City of Albuquerque
Stormwater Construction Site
Inspection Report

Project Name and Location	Generating at West Mesa 5th & Avalon		
Site Contact Name & Agency	Joe Cocchia Gorman & Gurney	ESC File No. NPDES ID No.	K11E004
Date of Inspection	1-9-19	Start/End Time	10:05/10:40
COA Inspector Name	Curtis Cherne, Stormwater Quality		
Describe Present Phase of Construction	Constructing bldgs

**Re: Generations at West Mesa
Erosion and Sediment Control Plan
Engineer's Stamp Date 7-21-18 (K11E084)**

**Re: Generations at West Mesa
Erosion and Sediment Control Plan
Engineer's Stamp Date 4-24-18 (K11E084)**

Drawing file: ESC2 / 24x36 Generations Stamped ESC Map.pdf

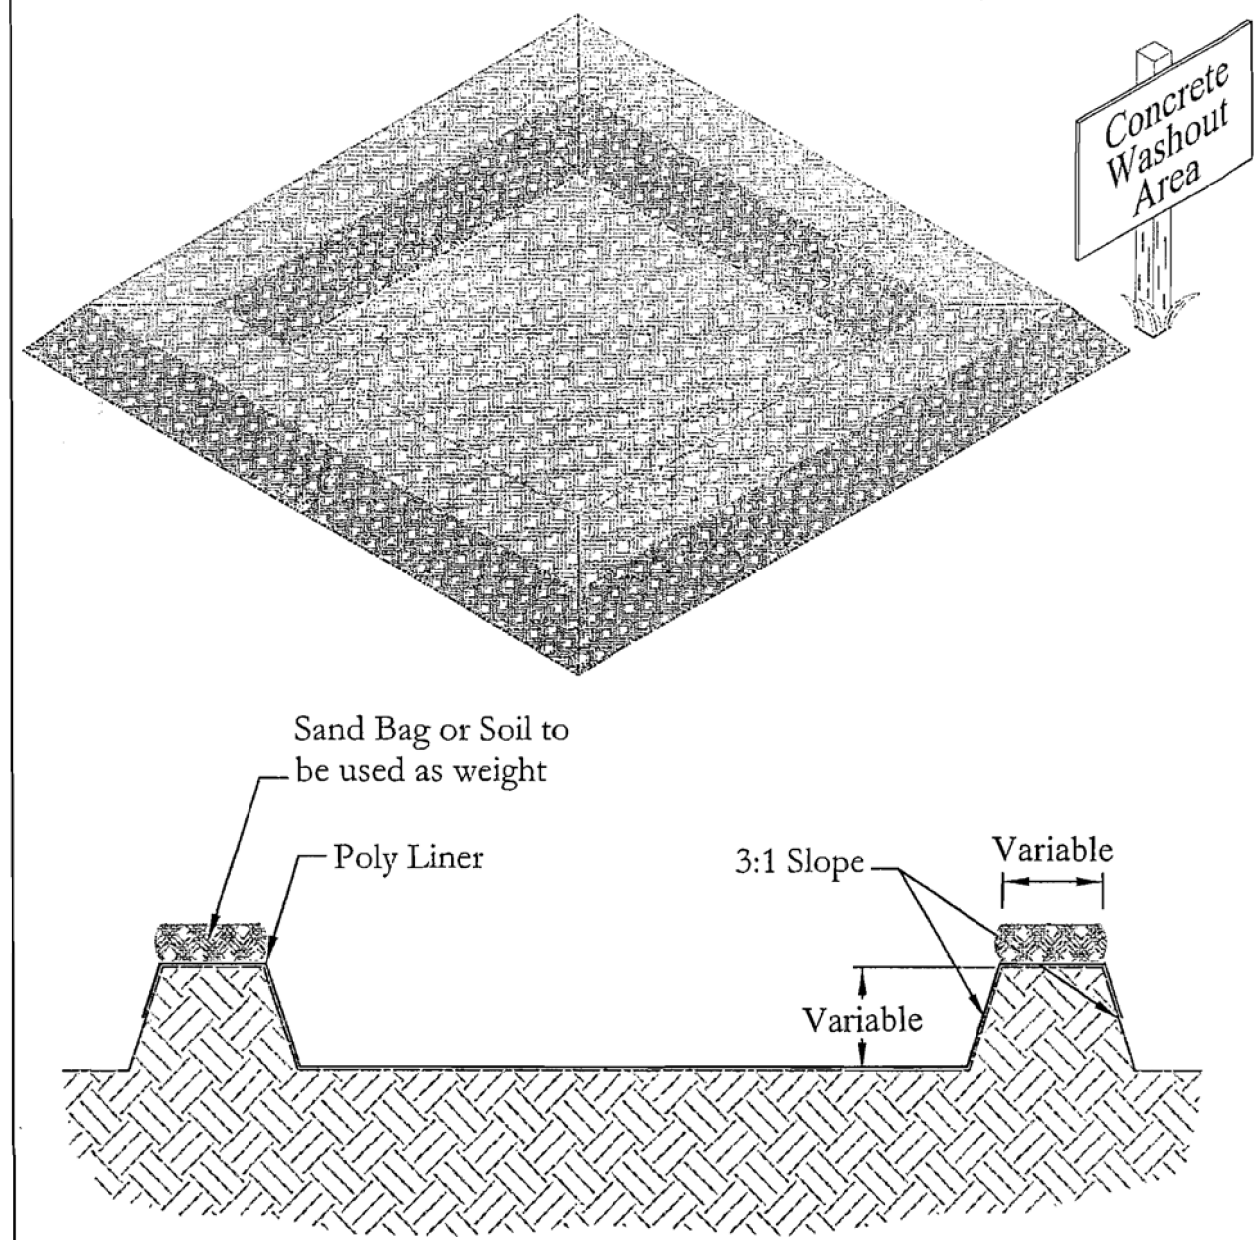
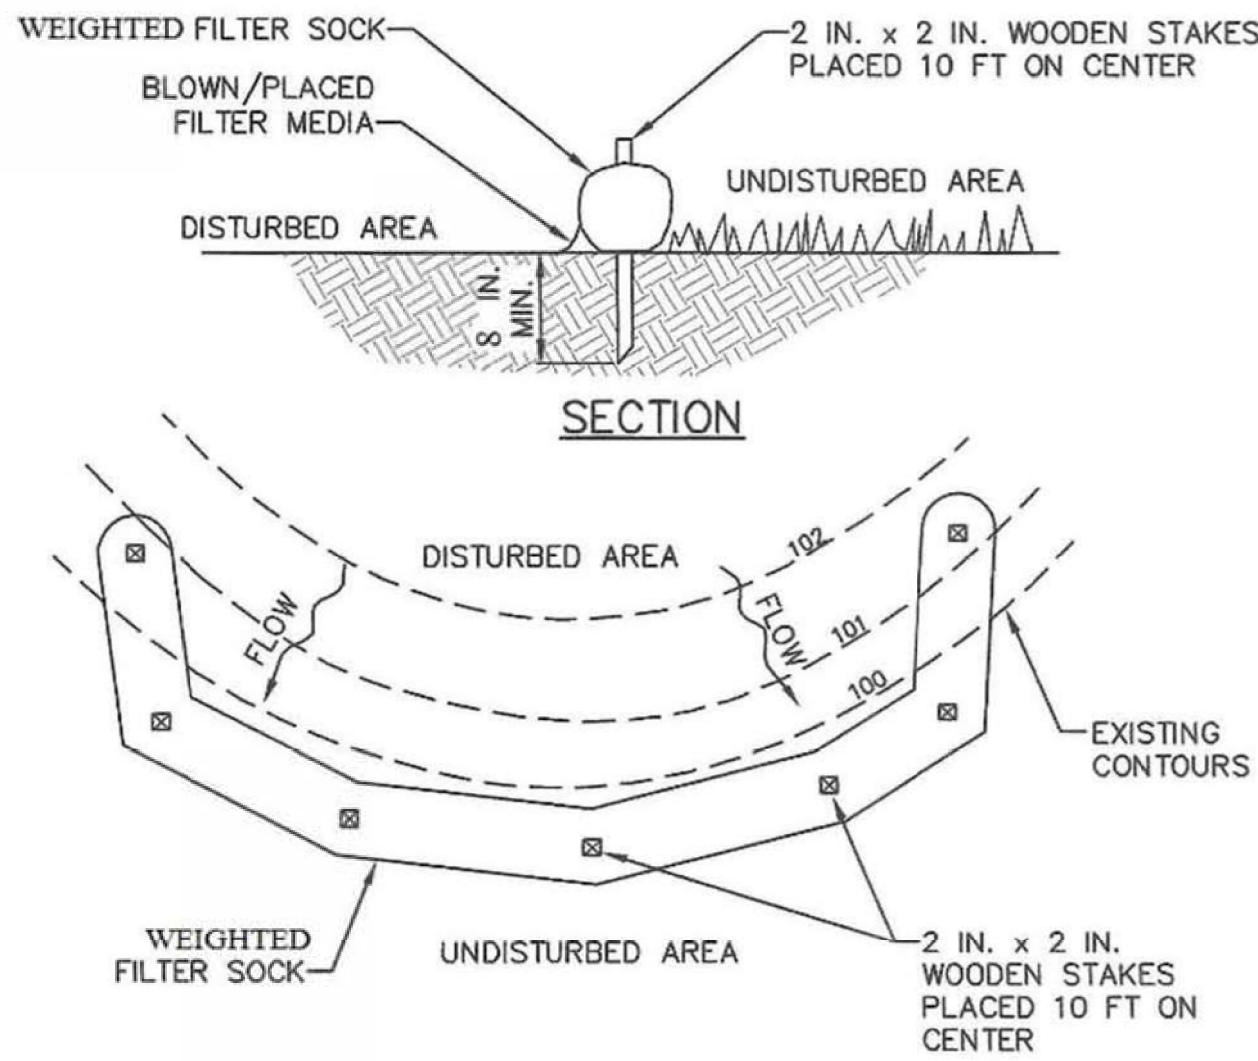
1. The plan does not show proposed grades.
2. Fencing cannot be used as a sediment BMP.
3. The plan does not have a Vicinity map.
4. The plan that was approved, Cypress Civil Development stamp date 4-24-18, did not have Vehicle Tracking Control proposed at the SE corner as it is a downhill location. These usually get mucked-up due to site drainage. It was omitted with the resubmittal.
